**SOUTHEASTERN SOIL &
ENVIRONMENTAL**

Regarding: Cale Barnes, Popes Lake

Re: Cale Barnes Property, Popes Lake, Phase III, Lot 3

PROPOSED SUBSURFACE WASTE DISPOSAL SYSTEM DETAIL SHEET

Harnett County Department of Public Health Site Sketch

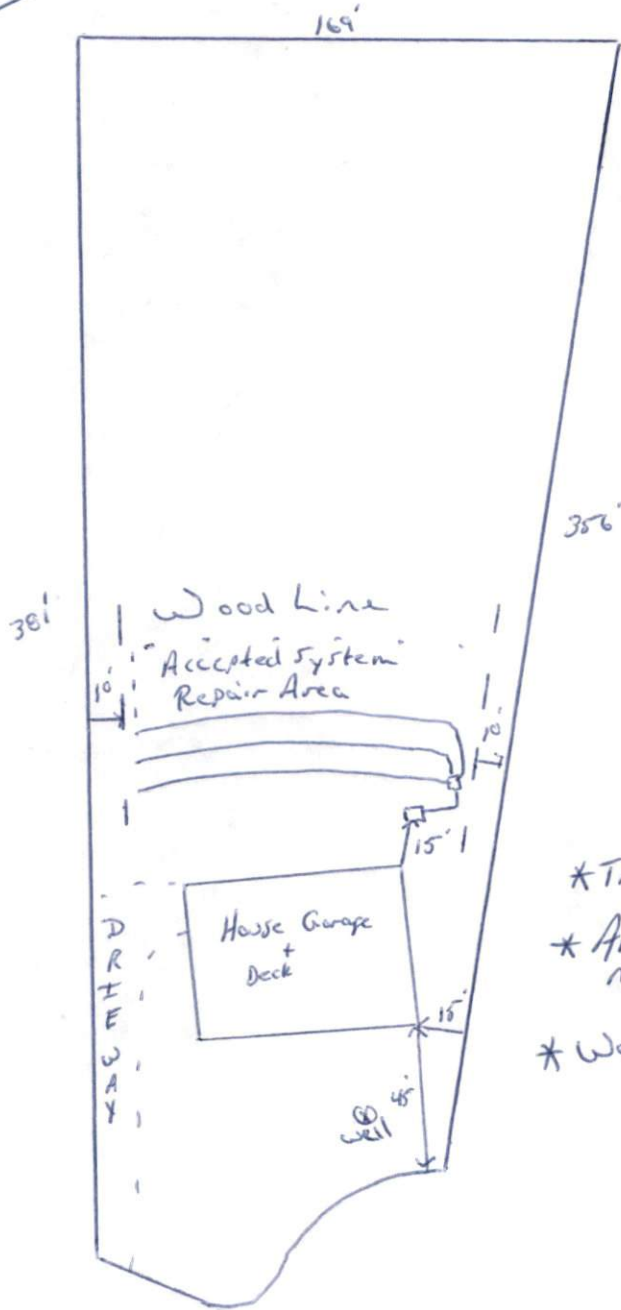
I have designed a new system for C. Barnes trying to allow space behind his home. I used your repair as the initial and pumped new repair to front. The well in front is to be abandoned. Please field review & let Cale Barnes know if you concur.
